P/123/20/L

Pennicotts Farm Pagham Road Pagham PO20 1LN

Listed building consent for the demolition of existing conservatory to southern side of building & general repair & maintenance of external brickwork & roof coverings, insertion of 2 No conservation style rooflights to the rear valley roof, & formation of 2 No sets of double patio doors within existing window openings on the northern elevation. Internal alterations comprising the removal of partition walls, reinstatement of wooden balustrade to staircase, and general repair, maintenance and refurbishment

Title	Photo Documents CLD
Client	Mr. S. Cox-Rusbridge

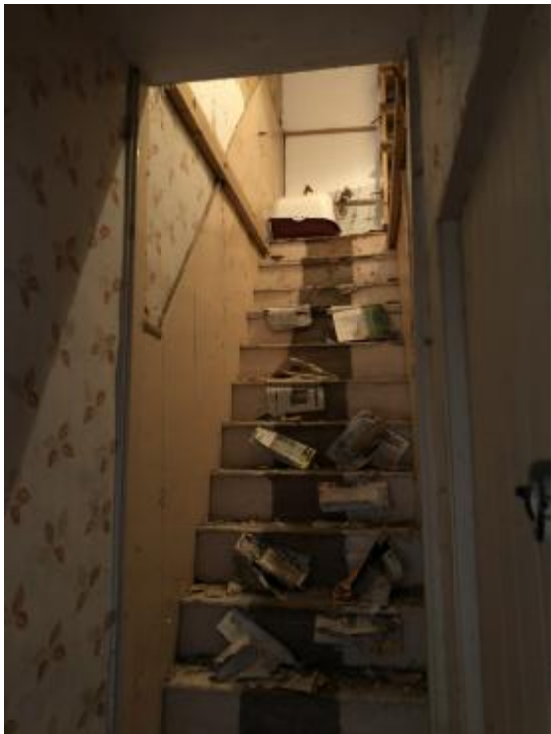
In the absence of any information regarding the general repair and refurbishment of the listed buildings, any materials used should be appropriate and, for instance, allow the building to breathe. It would be helpful to understand how the staircases will be treated so as to ensure that this element is appropriate.

Title Front Elevation
PROPOSED
Client Mr. S.
Cox-Rusbridge

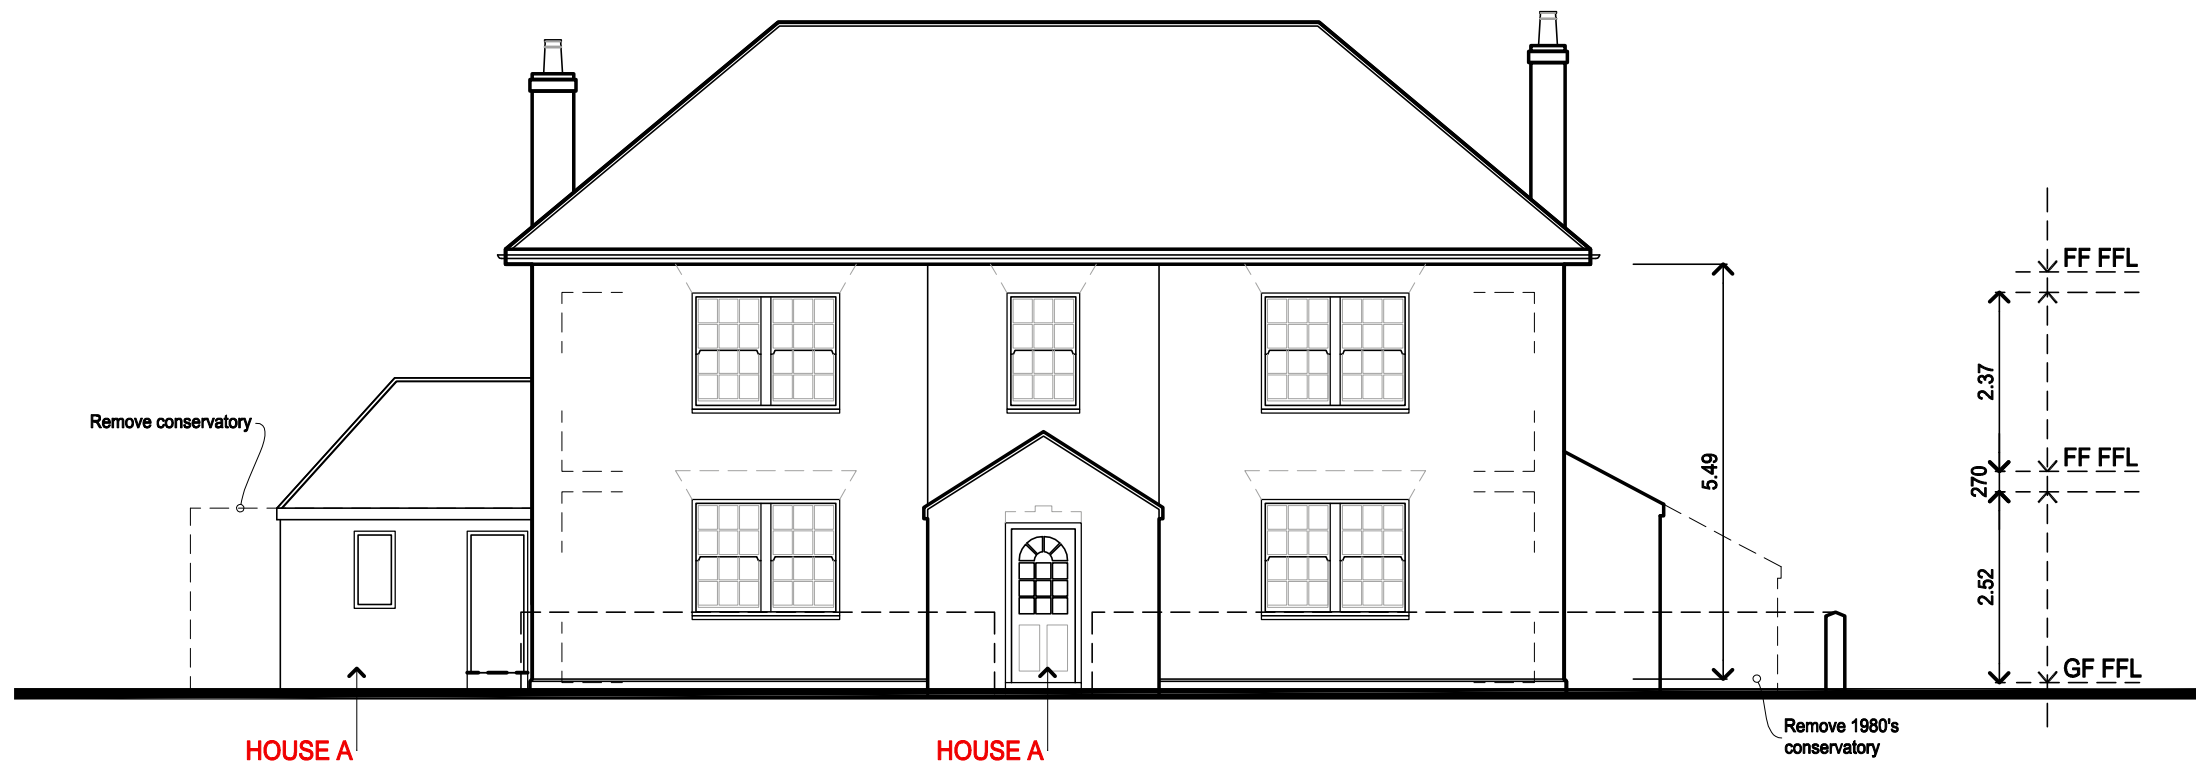
Externally, the demolition of the modern conservatories is a positive proposal, as it will remove two extensions that harm the significance of the building and ensure that a more appropriate elevation is returned to view.

Title	Side Elevation PROPOSED
Client	Mr. S. Cox-Rusbridge

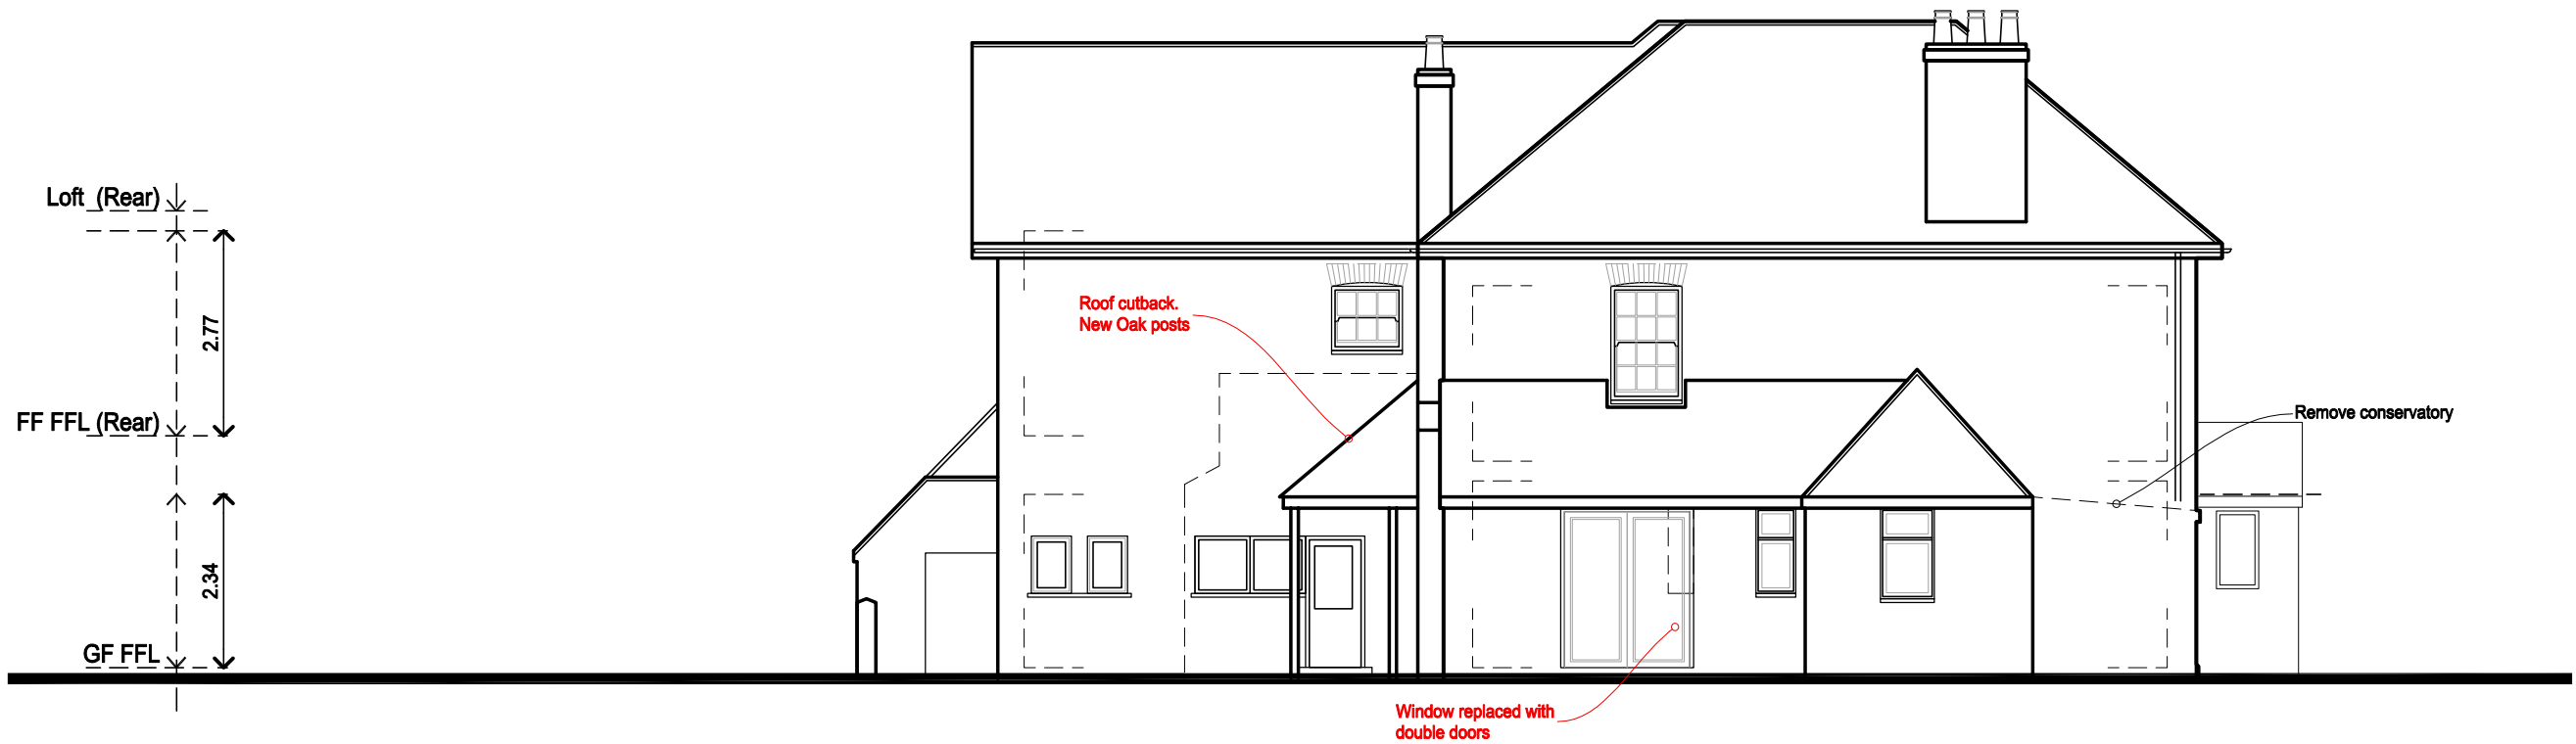
The insertion of 2 conservation style rooflights to the rear valley roof, and formation of 2 sets of double patio doors within existing window will result in the removal of historic fabric. However, the amount of fabric affected is fairly small and, subject to the design of the replacement doors is

acceptable. Further, the new doors will be on the side elevations which means that the principal elevation will not be affected.

Whilst details of the windows and internal doors have been provided, it is not clear what the external doors/French doors will look like. Details of these should be provided, along with their treatment if you are minded to approve the application
